Angus Place Extension Project – SSD 5602

Attachment A: EPA comments

Figure 5.2 Time series of 24-hour average PM₁₀ concentrations – Bathurst AQMS – 2014–2018

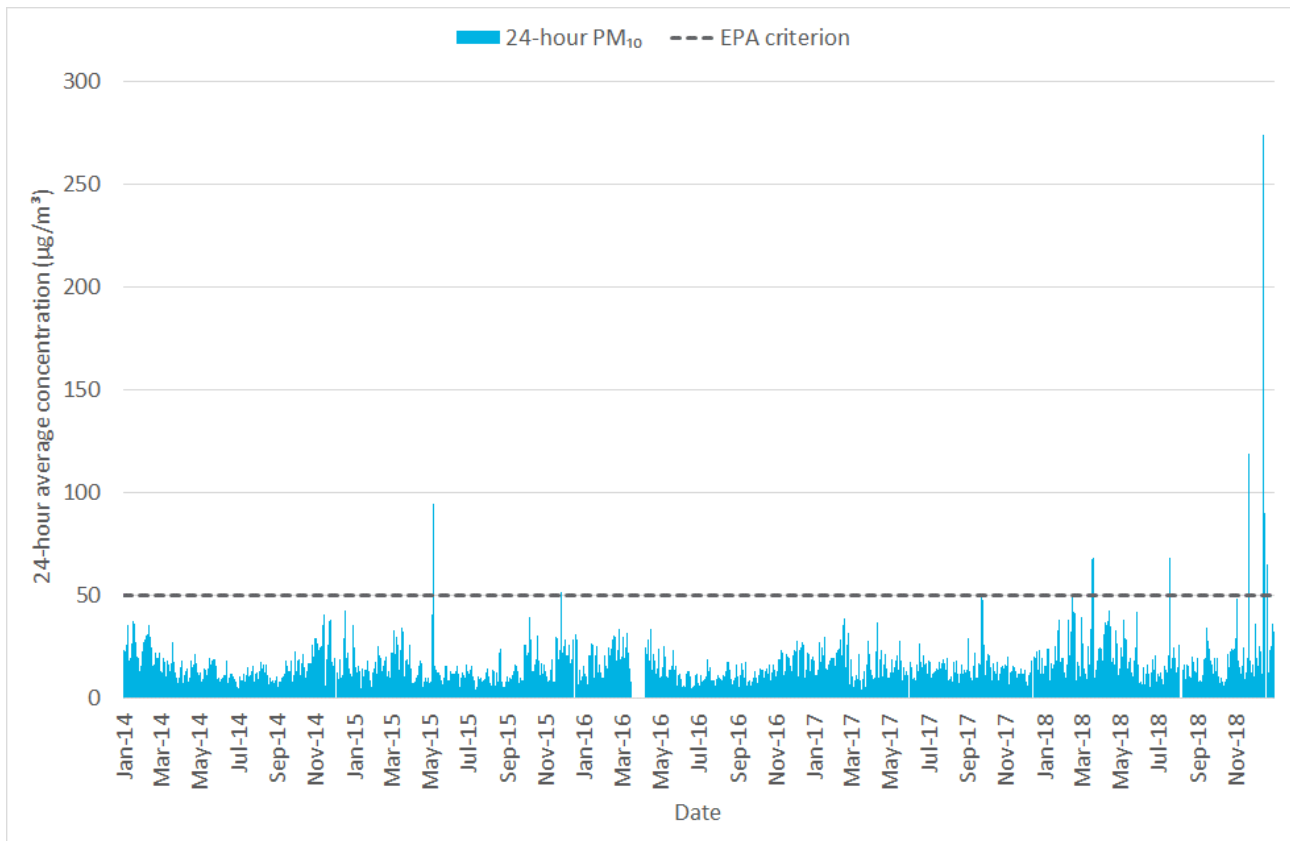
The AQIA uses background air quality data from Bathurst AQMS but has removed data points that are above $50 \mu\text{g}/\text{m}^3$ and those that were measured during regional dust storms. The AQIA states this is consistent with the approach in the Approved Methods.

The use of air quality data from the Bathurst monitoring station might be conservative as stated in the AQIA with comparison to onsite PM_{10} data collected by HVAS 1 in 6 days, but the excessive data manipulation to remove the 11 highest values in 24-hour PM_{10} data, including three data points that are below the impact assessment criteria ($50 \mu\text{g}/\text{m}^3$) is not adequately justified and not an approach supported by the Approved Methods.

In particular, the three data points below that were removed due to widespread dust storms are likely to still reflect background air quality at the project location. The onsite HVAS shows a data point $>100 \mu\text{g}/\text{m}^3$ indicating that the removal of background data from Bathurst $>48 \mu\text{g}/\text{m}^3$ is not necessarily reflective nor conservative of local air quality at Angus Place. If the eleven data values in background air quality were not removed, the modelling would predict three additional exceedances in PM_{10} 24-hour concentrations. The EPA advises that in the case of additional exceedances, the proponent must demonstrate that best management practices will be implemented to minimise emissions.

The EPA recommend the proponent revise the AQIA to incorporate background data consistent with the requirements with the Approved Methods. Where the revised assessment predicts exceedances of the impact assessment criteria, additional mitigation and control measures, including, but not limited to the ROM stockpile (issue 1b) should be applied to the project.
